CClaremout Business Park 2 Filing No. 1). 3

STREET IMPROVEMENT PLANS

APRIL 2020

EL PASO COUNTY FILE NO. SF-20-0014

STORM 5
STA 1+00.00 TO STA 5+92.88
(PRIVATE)

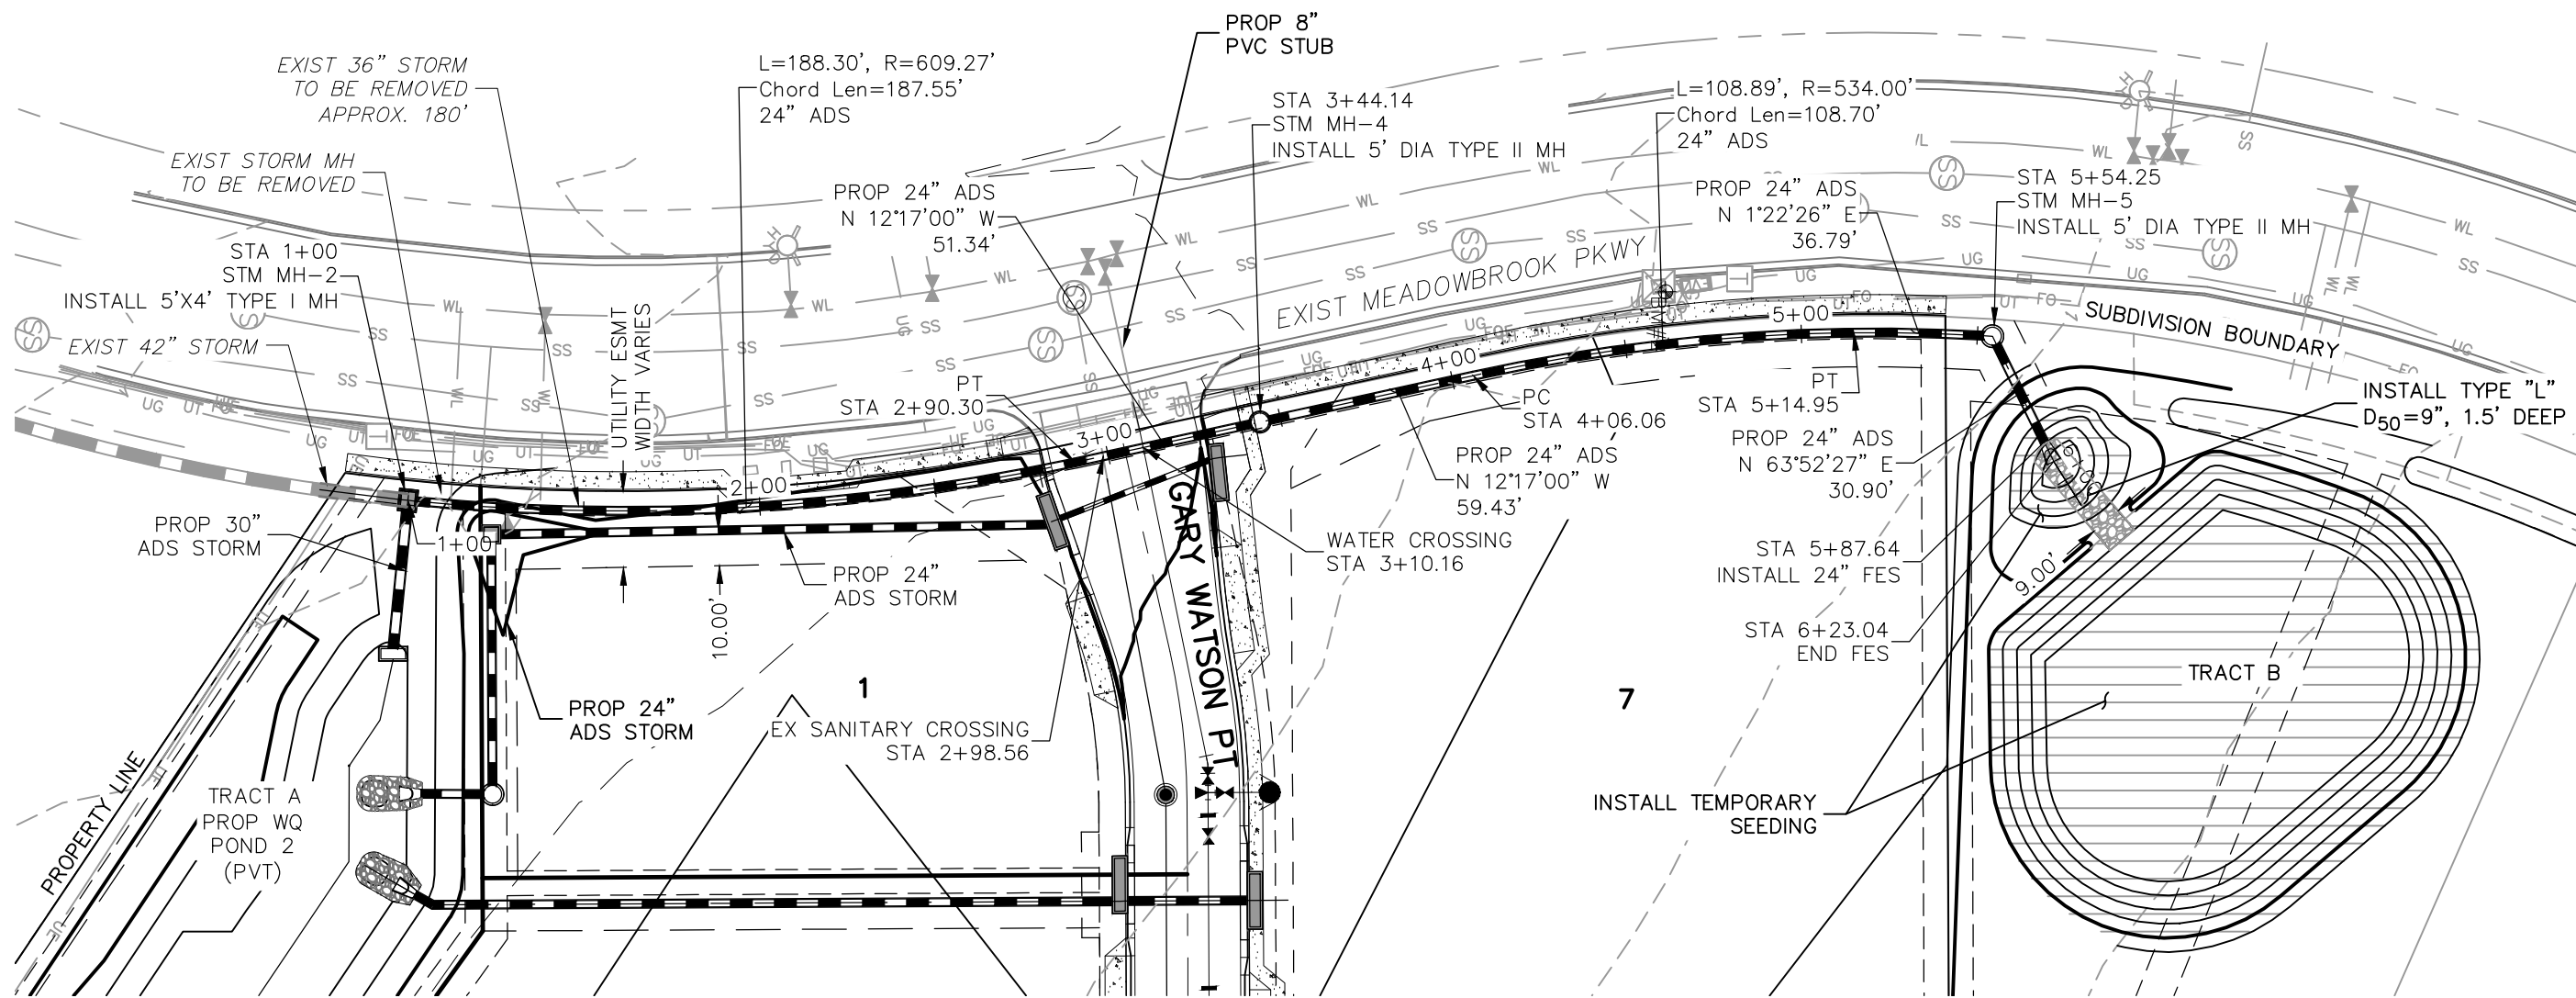
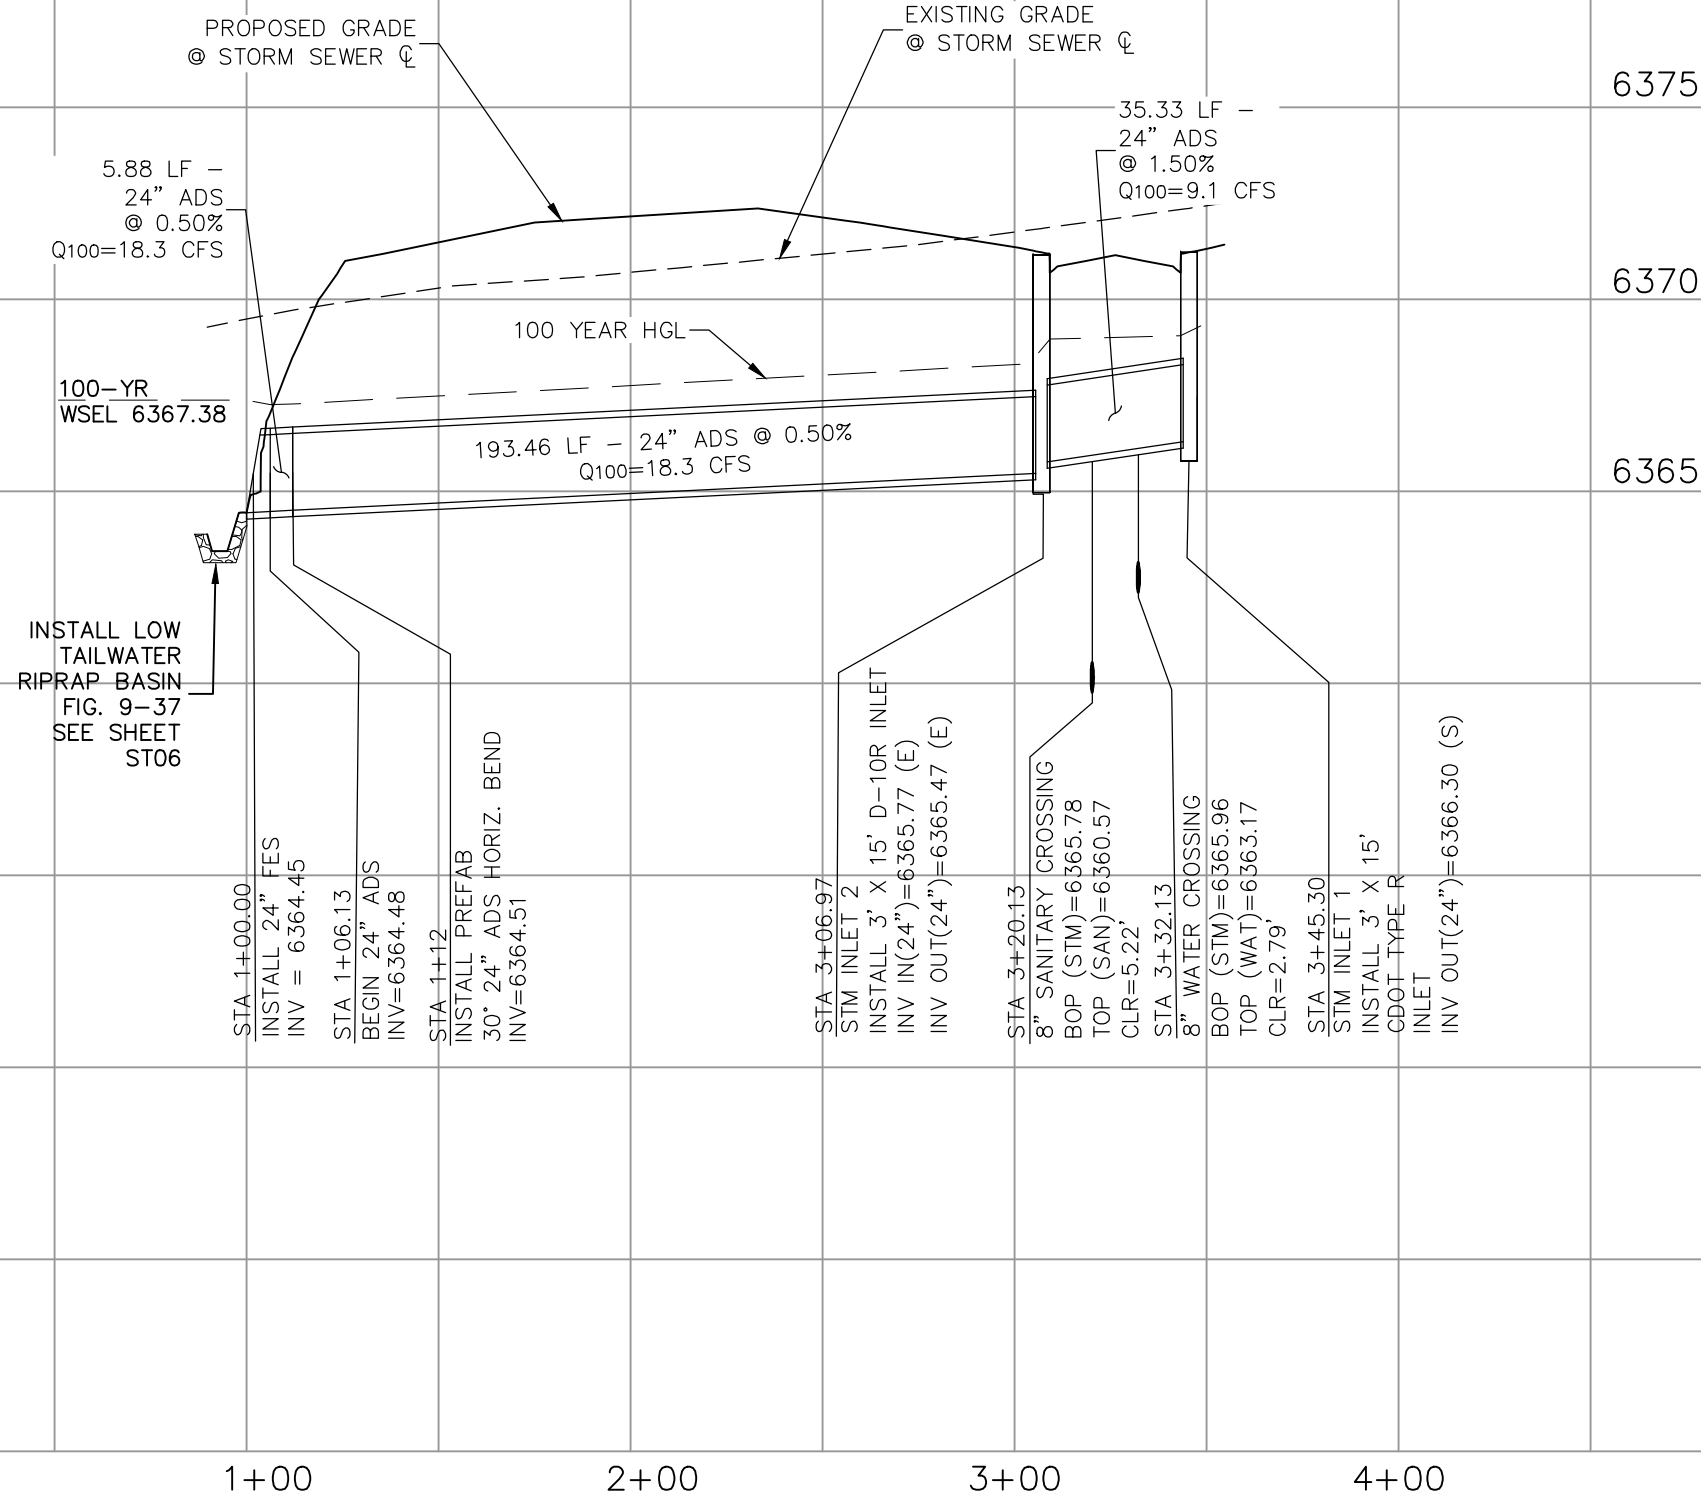
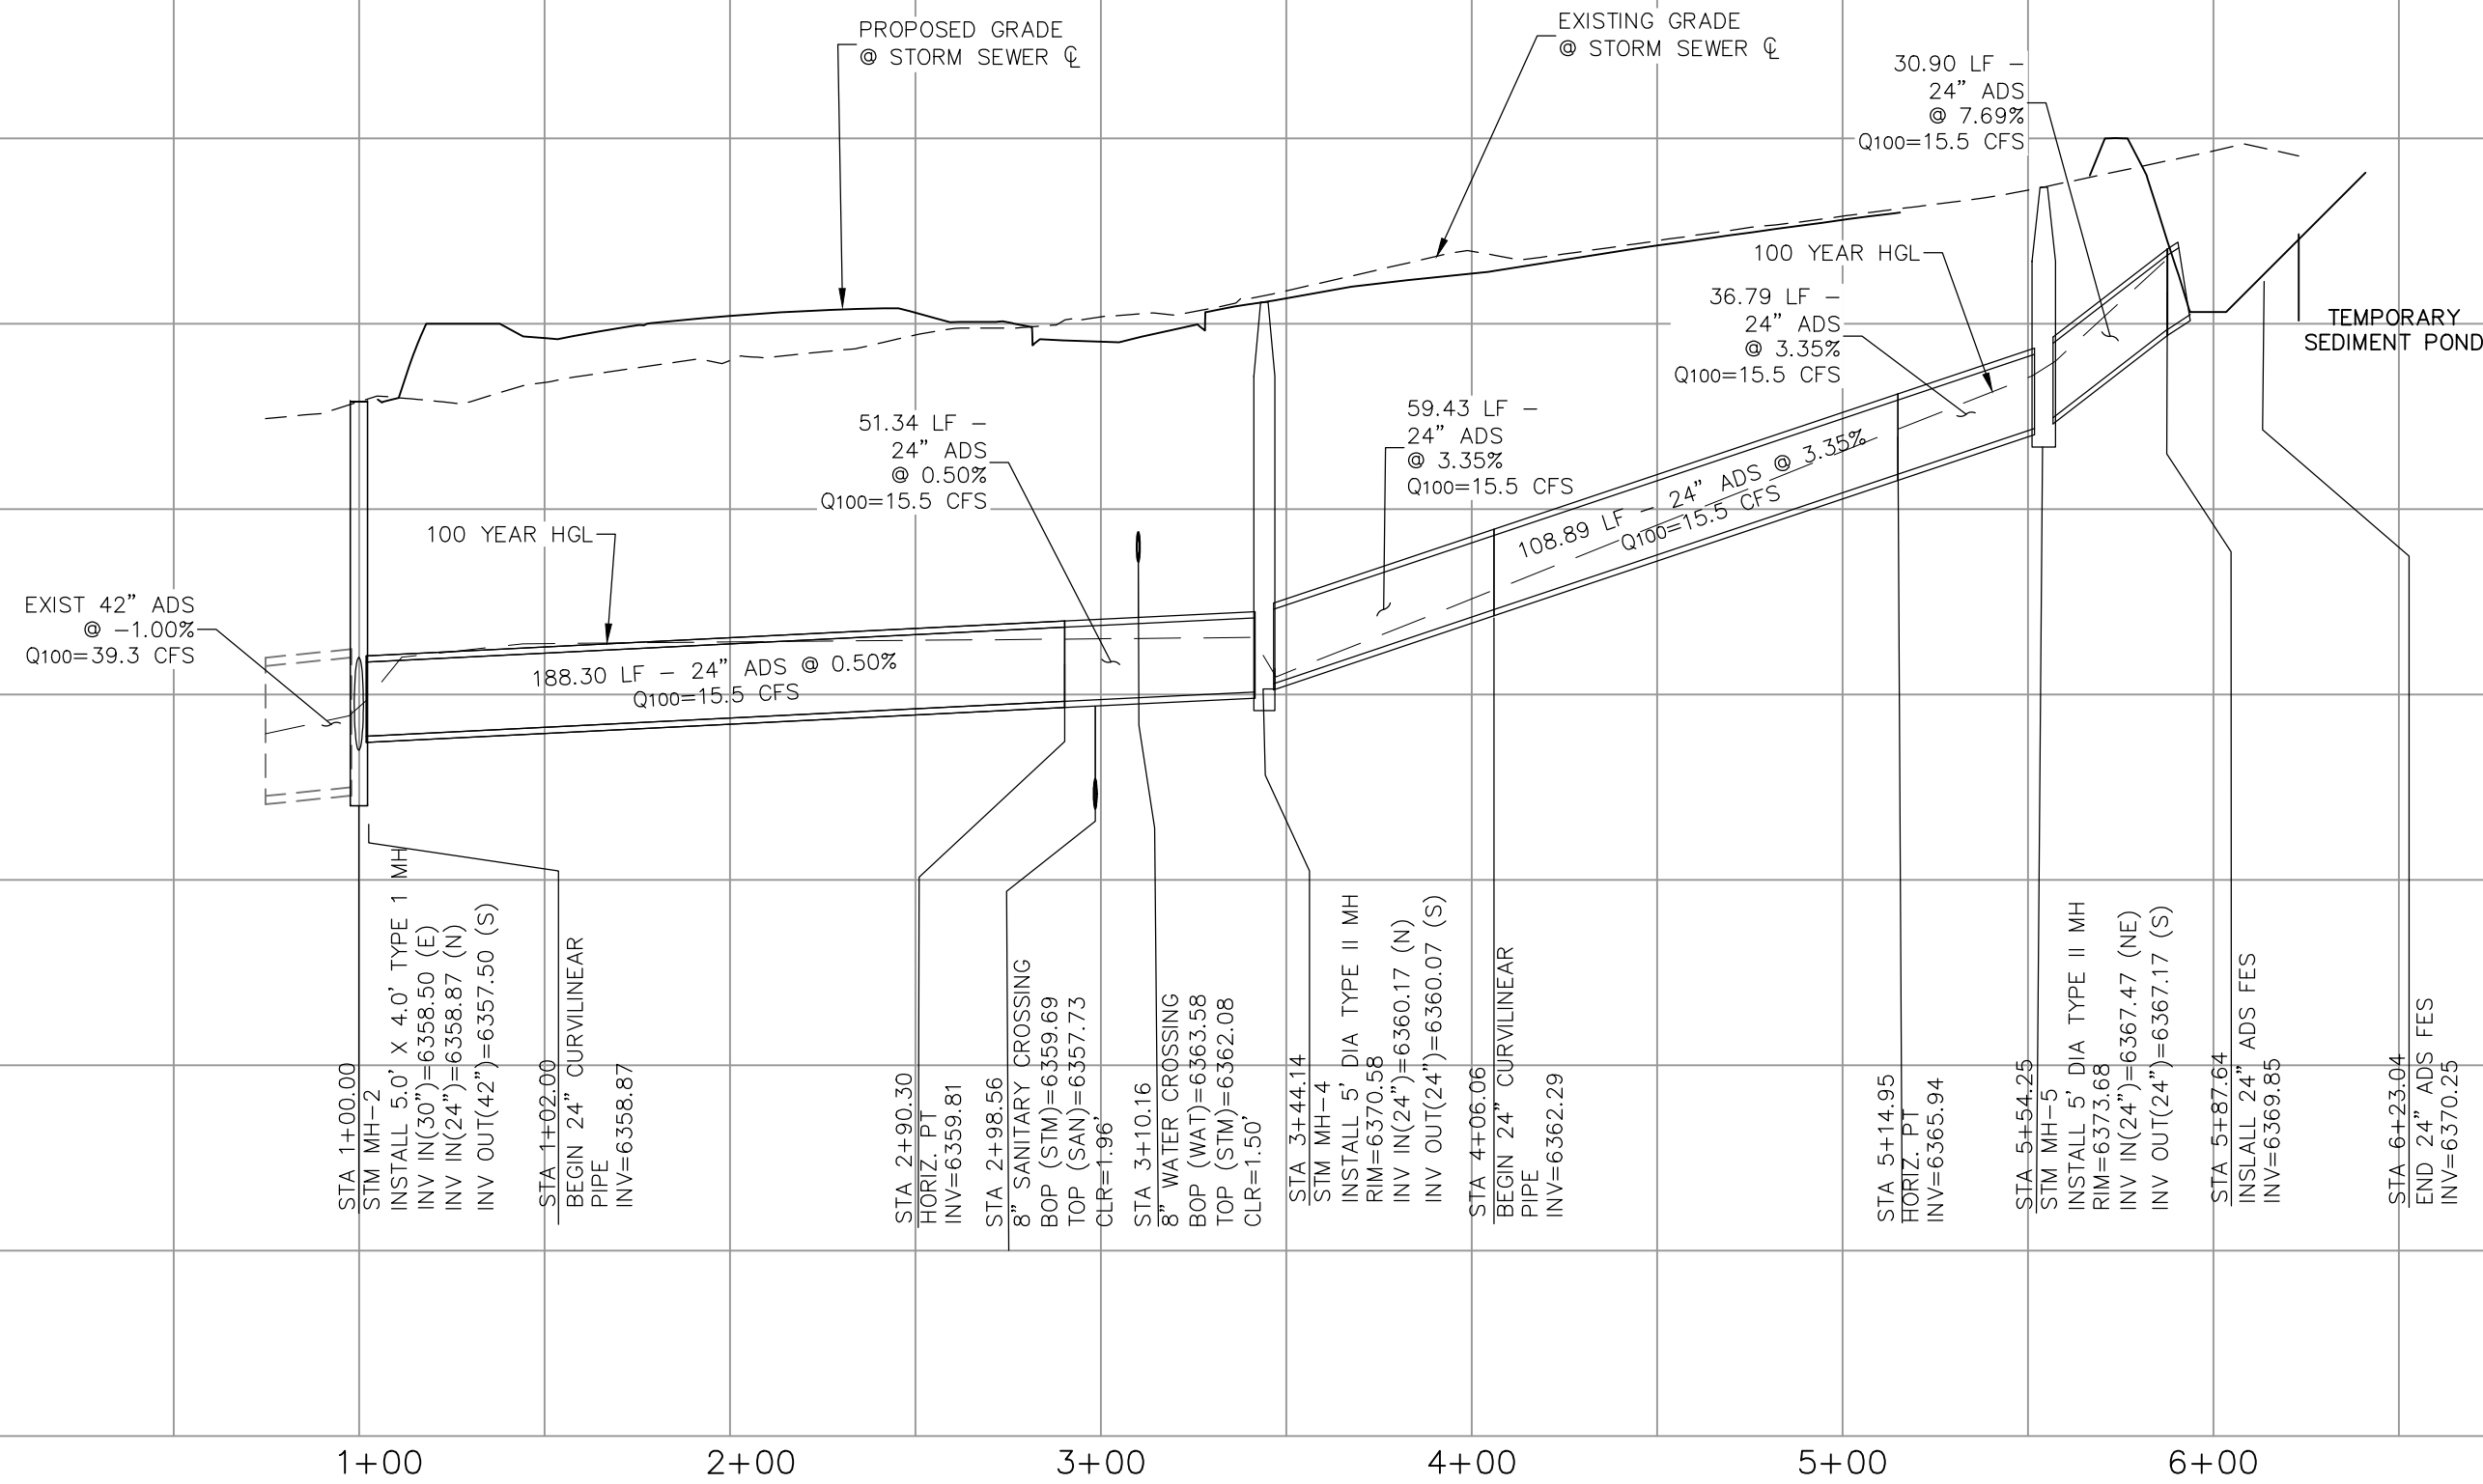
Identify the vertical scale
